June 23, 2015

**RE: Dreamstyle Warehouse, 1525 Renaissance Center
Grading and Drainage Plan
Engineer's Stamp Date 6-19-2015 (File: F16-D051A)**

Jeanne Wolfenbarger, P.E.
Senior Engineer, Planning Dept.
Development Review Services

TRACT 9A RENAISSANCE CENTER	DRAWN BY BJF
	GRADING AND DRAINAGE PLAN	DATE 06/10/15
	TERRA WEST, LLC 5571 MIDWAY PARK PLACE NE ALBUQUERQUE, NM 87109 (505) 858-3100 www.tierrowestllc.com	2015009-GRB
	SHEET # D2	JOB # 2015009

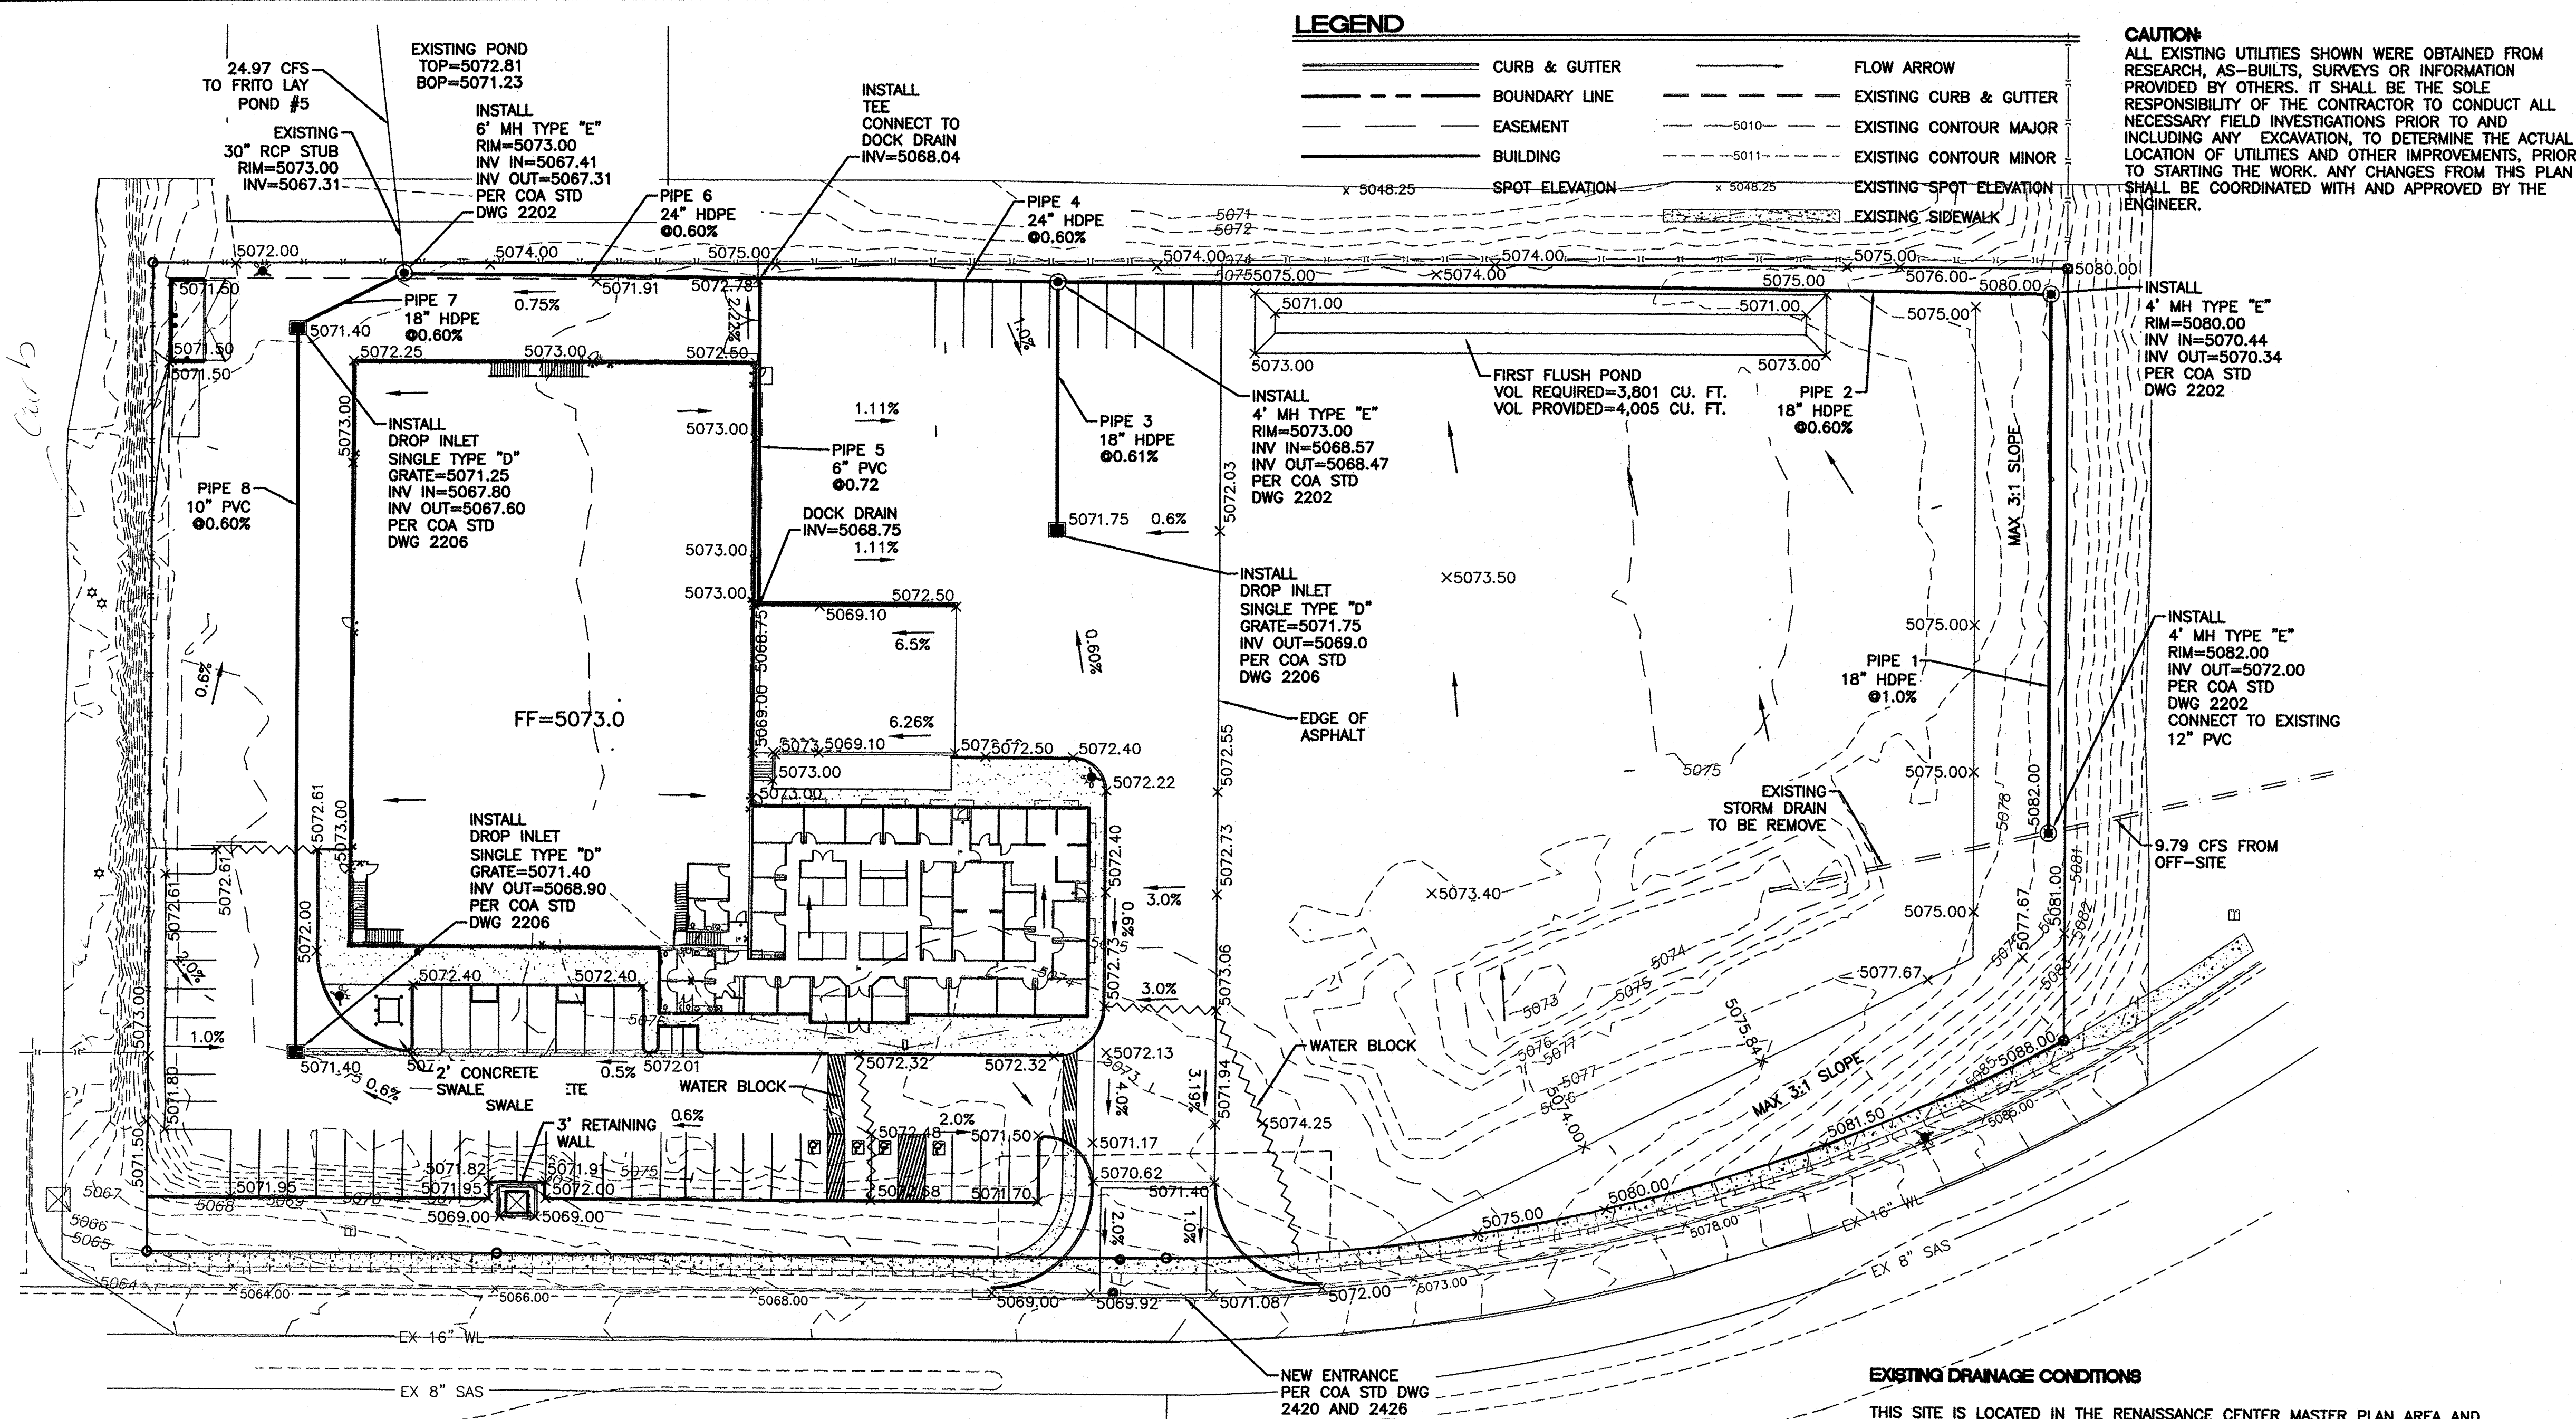
- 1) The first flush from the new building site must be retained. The off-site pond ("Pond 5") that is currently proposed to handle first flush does not meet the requirements because it is discharging the first flush at a controlled rate in lieu of retaining it. In addition to options mentioned from the last letter, another option may be to locate the pond just northeast of the new building within the area where the paved parking is shown and relocate the paved parking elsewhere. Along with the proposed change, state how first flush is to be managed on the grading and drainage plan in along with labeled required volumes.

- 1) Provide plat for Tract 9A that may show a private easement for the proposed storm drain that routes off-site flows through site. If one is not already provided, a paper easement is required.
- 2) In order to control the flow to allowable discharge of 0.66 cfs to the street, revise grades at the entrance.
- 3) The Type "D" drop inlet upstream of Pipe 3 does not show the capacity to handle the amount of flow listed for Pipe 3. Label curb along the west edge and other parking areas if applicable, and have a general note stating that the listed elevations are at the flowline as applicable. (There is a discrepancy between the spot elevation of 5071.40 and the grate elevation of 5071.25 near the northwest corner of the new building where the 5071.25 elevation appears to provide sufficient head to capture the required flow.)
